Item No.	Report of the Interim Director of Planning, Regeneration & Public Realm	
Address:	LAND ADJACENT TO 1A NICHOLLS AVENUE HILLINGDON	
Development:	Erection of a single building encompassing three self-contained, independent dwellings over two levels (two 1-bedroom ground floor units and a second floor two-bedroom unit) plus associated access, parking and landscaping.	
LBH Ref Nos:	54817/APP/2022/2568	
Drawing Nos:	Design and Access Statement NA03-01 Location Plan NA04-01 Proposed Site Layout Plan NA04-01 Existing Site Layout Plan NA05-04 Carport Elevations and Plan Covering Letter NA05-01 Proposed elevations NA07-01 Ground floor layout NA07-01 First floor layout NA08-01 Longitudinal section NA05-03 Building Shadow	
Date Plans received:	15-08-22	Date(s) of Amendments(s):
Date Application valid	15-08-22

This application seeks planning permission for the erection of a single building encompassing three self-contained, independent dwellings over two levels; including two 1-bedroom ground floor units and a second floor two-bedroom unit, plus associated access, parking and landscaping.

Proposed Front Elevation - E-01

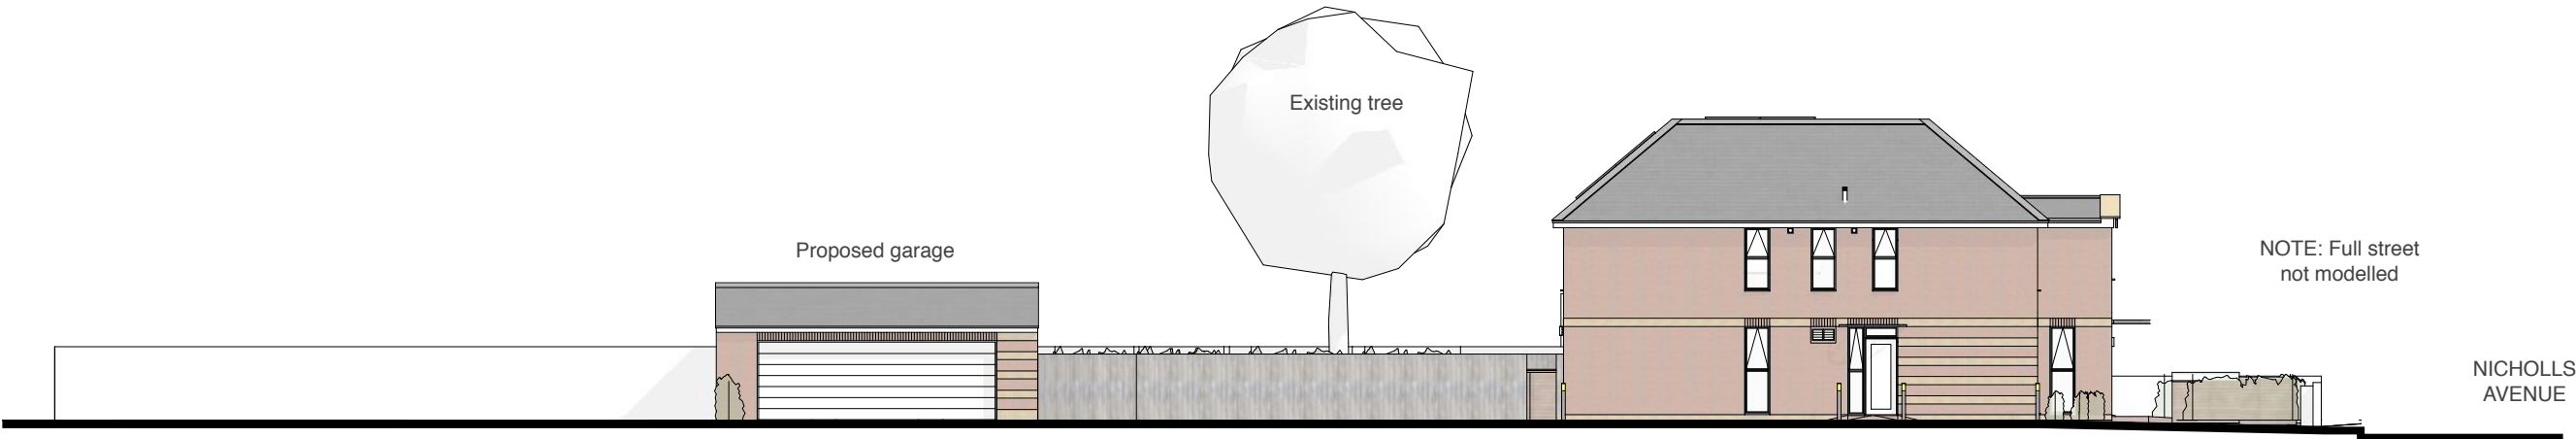
Due to its design, depth, bulk and scale, the resulting building, including its roof, would form an oversized, uncharacteristic and visually incongruous form of development which would fail to harmonise with the established character of the area and appearance of the street scene and locality. The proposal would therefore be detrimental to the visual amenities of the streetscene and the character and appearance of the surrounding area, all contrary to Policy BE1 of the Hillingdon Local Plan: Part One - Strategic Policies (2012), Policies DMHB 11, DMHB 12 of the Hillingdon Local Plan: Part Two - Development Management Policies (2020), Policies D1 and D3 of the London Plan (2021) and paragraphs 130 (a) and (c) of the NPPF (2021).

The proposed valley style roof is overcomplicated and contrasts with the simple designs of other roofs in the area. Due to its depth, location and height, the unusual design of the roof would be clearly visible when travelling from east to west on Nicholls Avenue causing adverse harm to the streetscene. Due to its small eaves to ridgeline (when viewed from the front) it would also appear as undersized, making the property appear bottom heavy and unbalanced. The property would be further visually unbalanced by the oversized projecting front gable on its front elevation. The front gable seeks to mirror other gables on the road, however due to its large roof, depth, excessive width, height and siting on the front of a two storey property, it is considered to result in a property that is contrived and architecturally confused between being a bungalow and two storey dwelling. The proposed first floor roof garden would add a uncharacteristic feature to the area.

Plan of garage

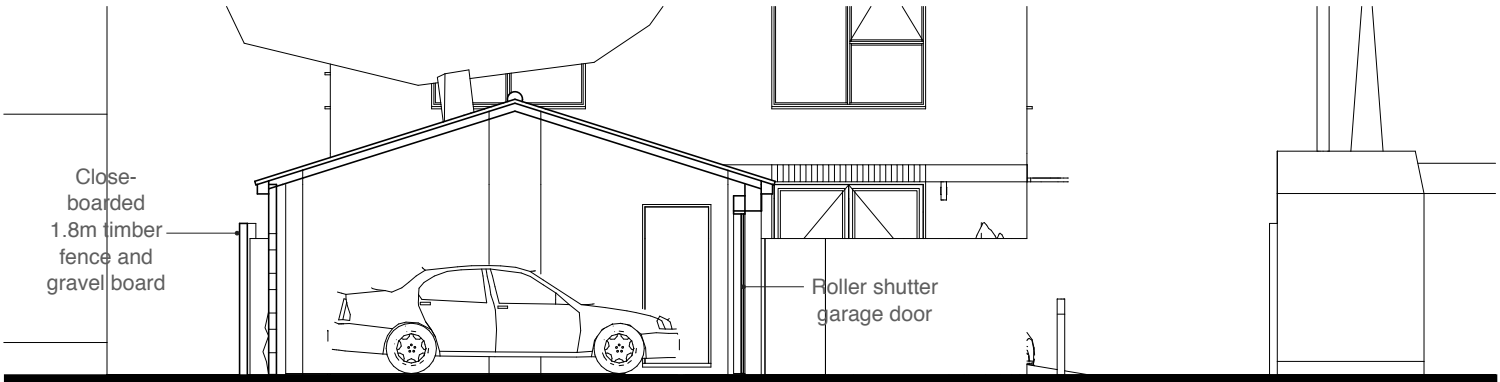
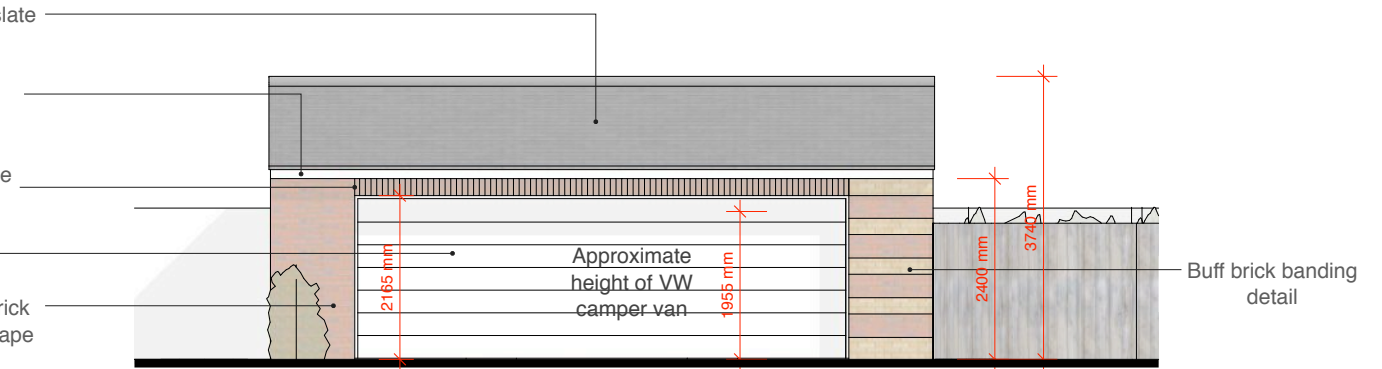
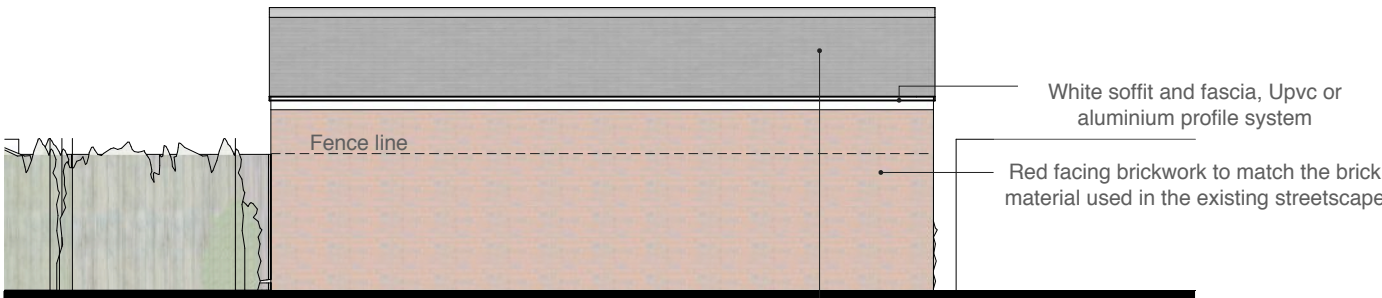
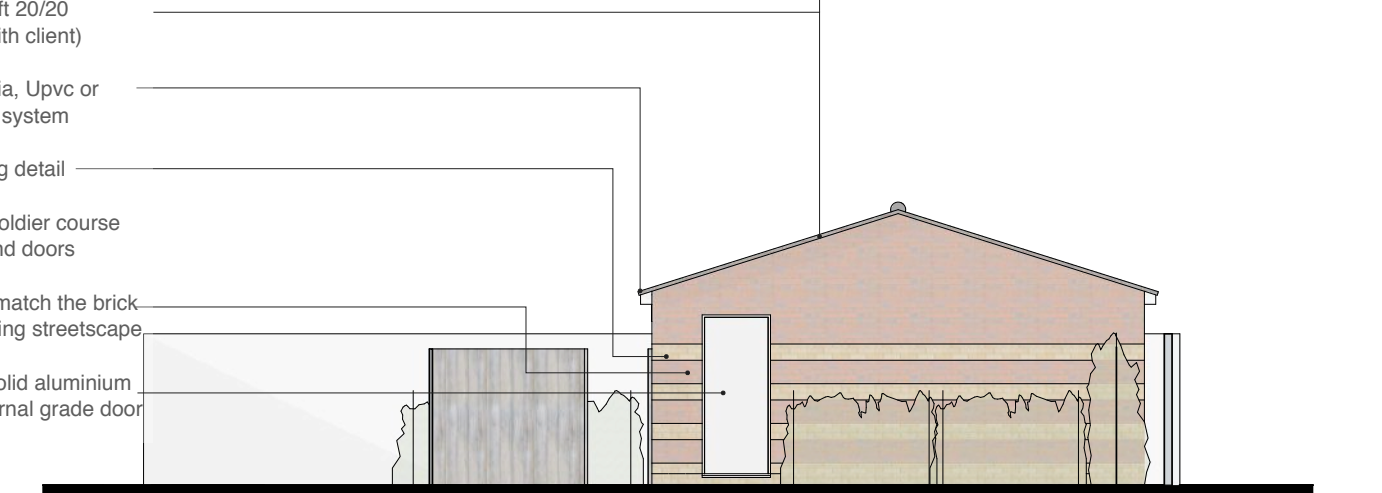
At the rear, due to its 3m height, 70sqm footprint and siting in the middle of the development site (which would appear to be split for two uses), the rear garage would fail to follow the established pattern of garden development in the area, which is made up of smaller buildings sited to the most rear of their sites, well away from the sites main building.
